GRANDVIEW RESERVE FILING NO. 1

Engineering Review
10/27/2021 3:01:26 PM
dsdrice
JeffRice@elpasoco.com
(719) 520-7877
EPC Planning & Community
Development Department

EARLY GRADING & EROSION CONTROL PLANS

PUDSP2110

Sediment Basin (SB) SC-7

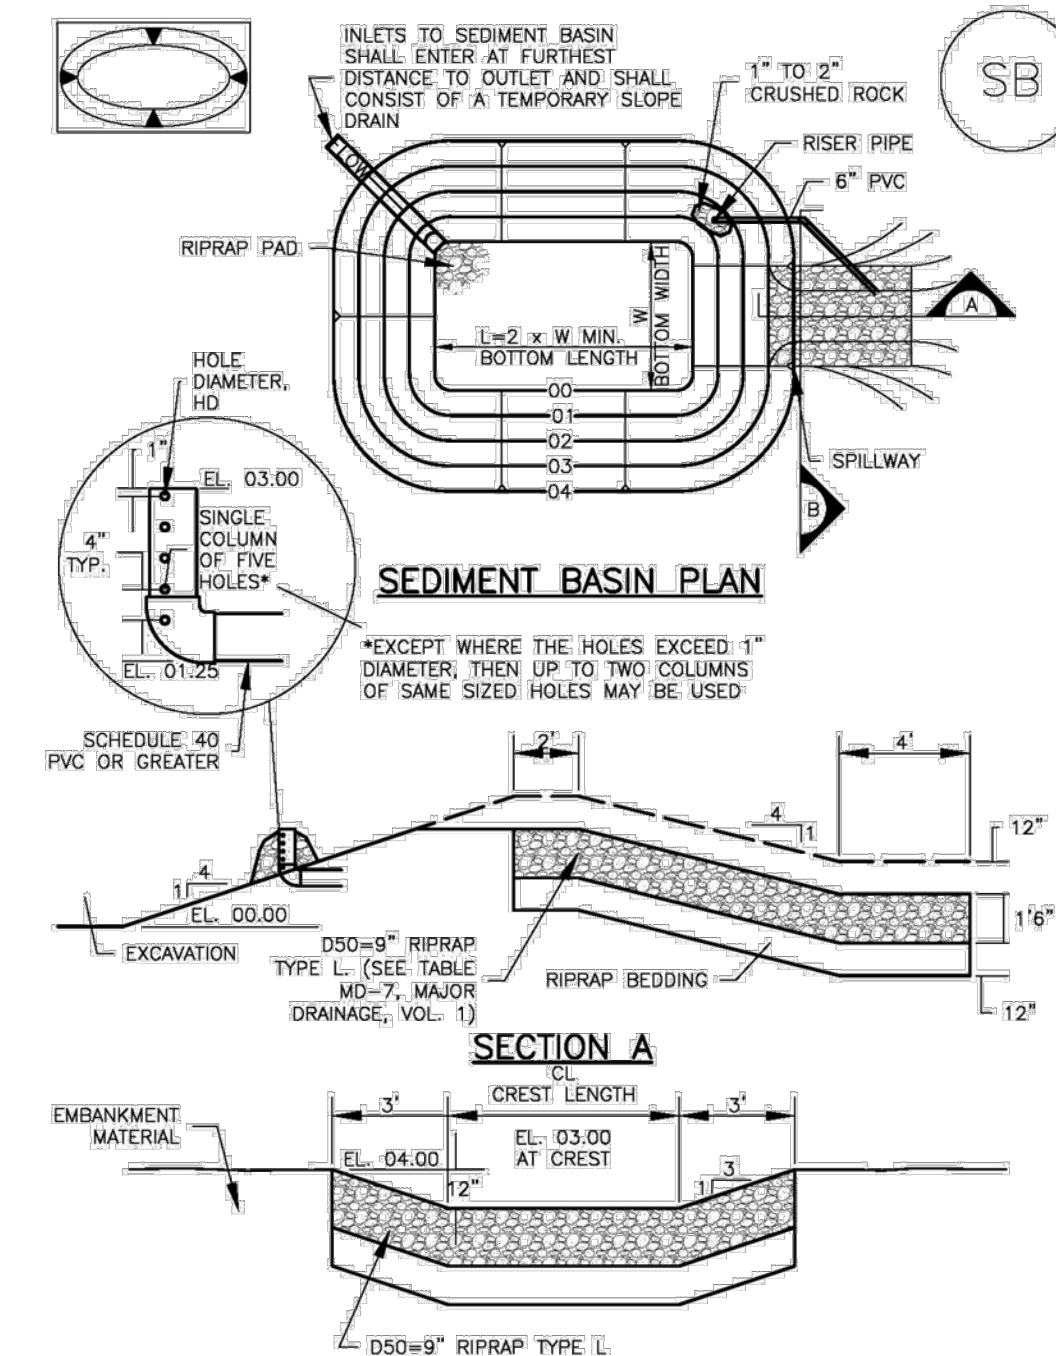
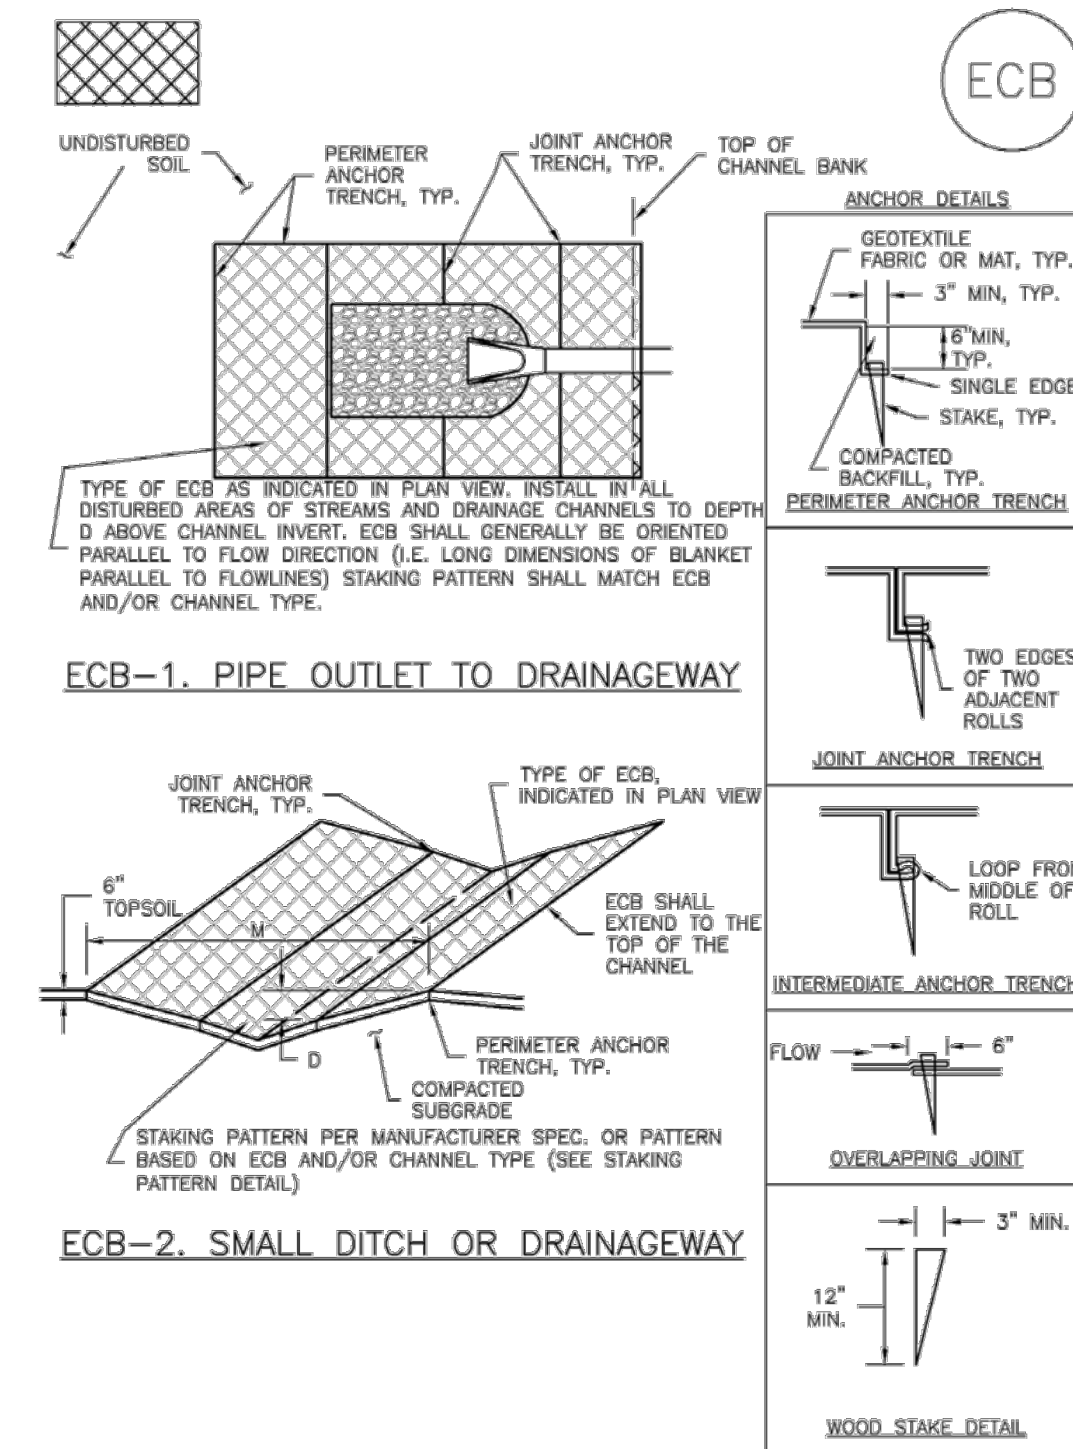
Provide details of temporary sediment basin including riser pipe perforation sizing, number of rows, required volume, location of outlet and spillway, and tributary area to the sediment basin.
